**Concept Development Application (Staged Development) for Alterations and Additions to the InterContinental Hotel and Transport House, Sydney (SSD 7693) - Notice of Exhibition.**

Objective Reference- CD17/10495

Figure 11: Potential construction zone in Macquarie Street

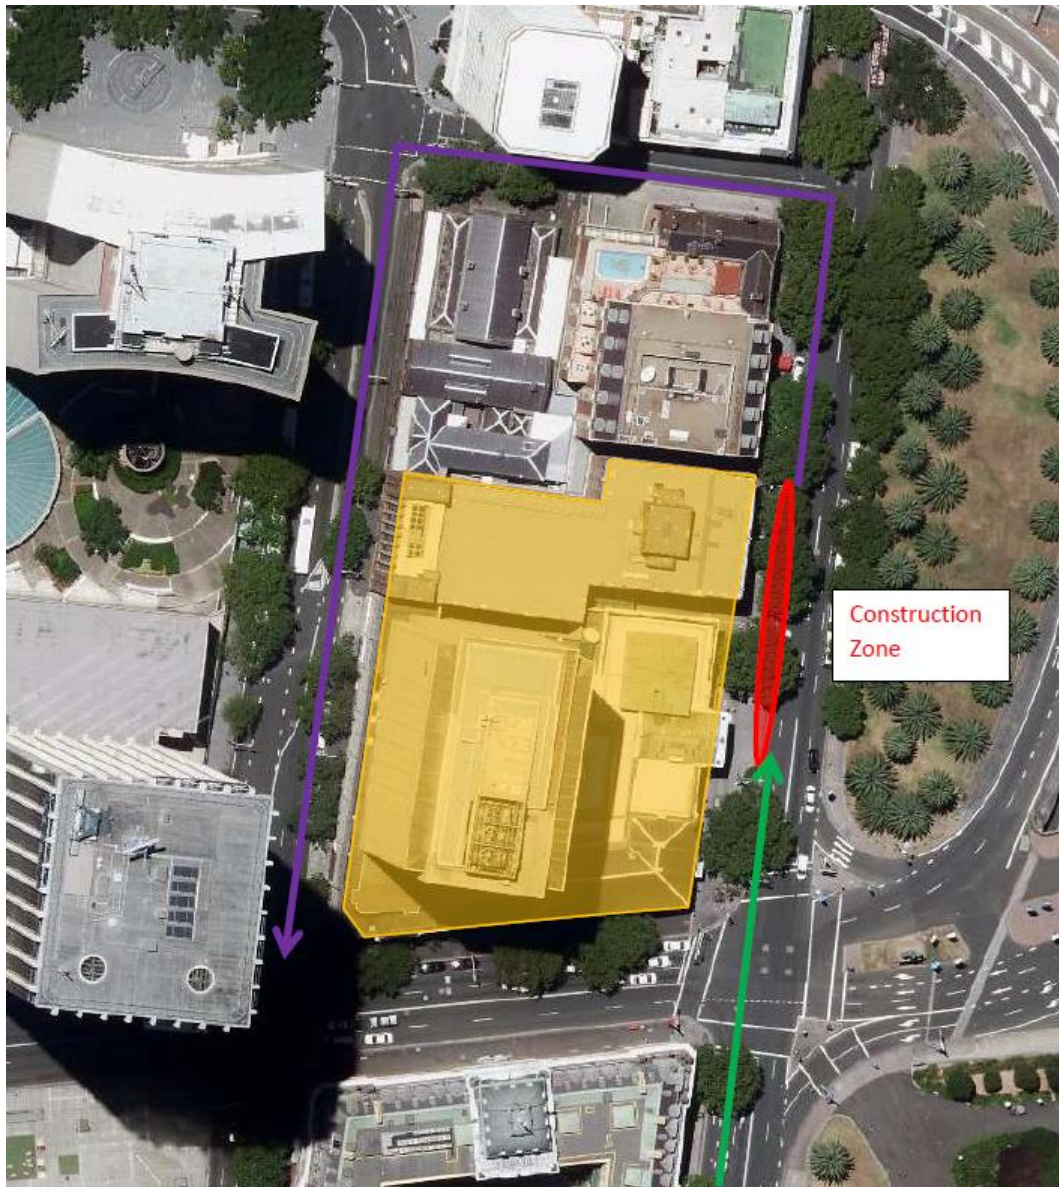
- In addition, the proposed works zone in Macquarie Street appears to conflict with the use of this space for coaches and drop off/ pick up vehicles as part of the general operation of the hotel.

- Further details on how the proposed works zone in Macquarie Street be managed with coach and drop off/ pick up vehicle activities; and
- The applicant prepares a draft Construction Pedestrian and Traffic Management Plan (CPTMP) in consultation with the Sydney Coordination Office. The CPTMP needs to specify, but not limited to, the following:

Figure 12: Construction access routes

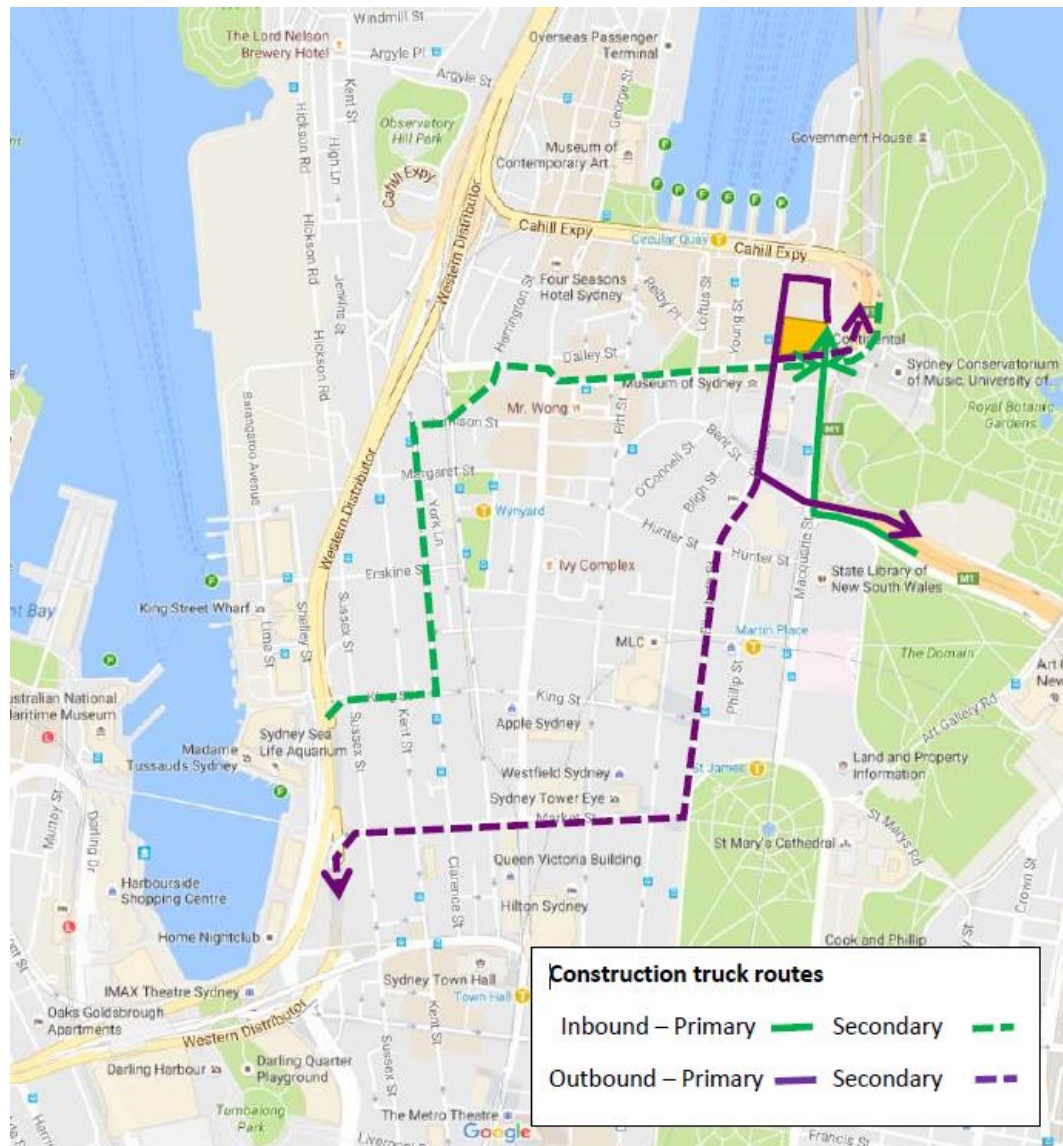
- The primary and secondary traffic routes shown in the Traffic and Transport Assessment be modified to minimise the impact on bus services, particularly in Phillip Street, and key traffic corridors, in particular Bridge Street; and
